From: Maria Tomalova [REDACTED]
Sent: 14 September 2021 10:50
To: [REDACTED]
Subject: BR/119/21/PL

Component: **Proposed East Elevation**

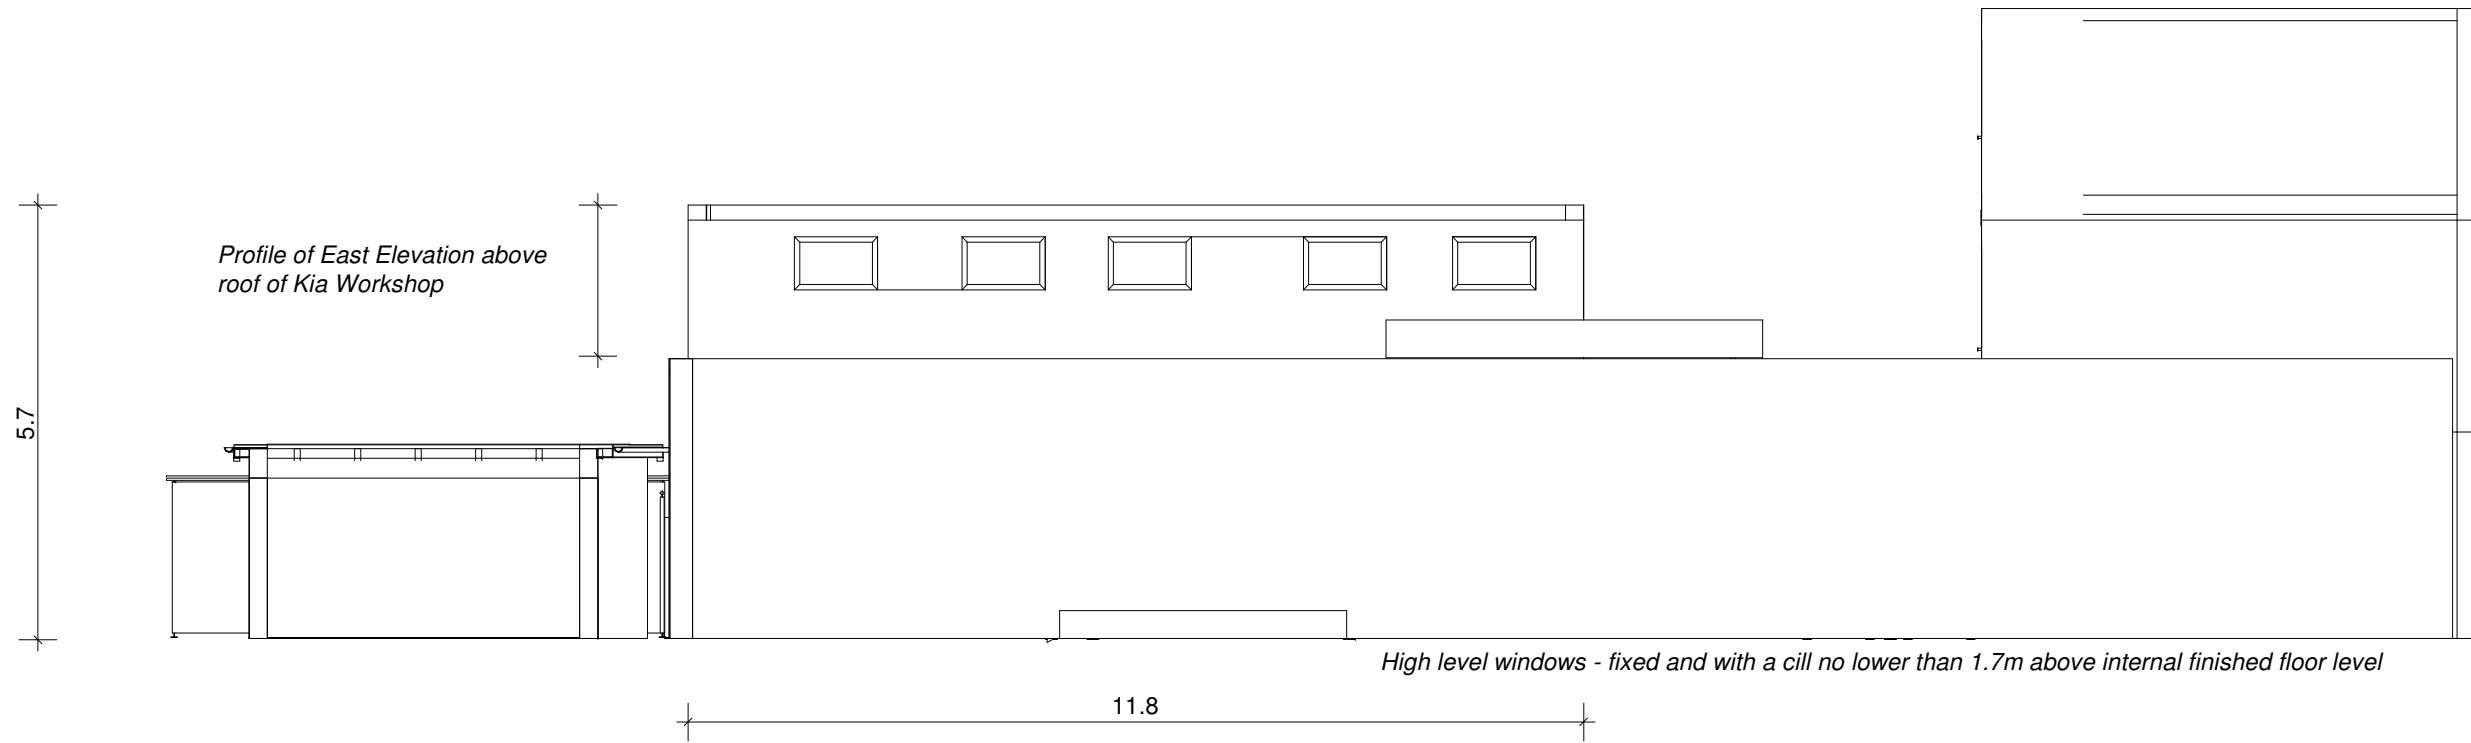
What you are proposing is not a mews but an inappropriate extension.
The proposed rear extension would visually dominate an existing building its immediate surroundings.
Its design fails to reflect the style of host building (there was a confusion if the proposed is an extension or an another building attached to the rear Of 73-75 Aldwick Road).
The extension would rise above the penultimate storey of an existing building.
It would occupy an extensive part of the yard.
It would upset the proportion of an existing building.
Would be visually intrusive/unsightly when seen in longer public or private views from ground and upper levels.

The rear garden of No 10 Stocker Road would be observed from the first floor windows of proposed with a distance of 7m.
The existing terrace and balcony of an host building would be overlooked from the first floor windows as well.
The living condition of prospective occupiers: Bed 2 of 2bed unit above 2 floors would be lit through the well between 73 and 71 with no outlook and proper ventilation (Fire escape?).
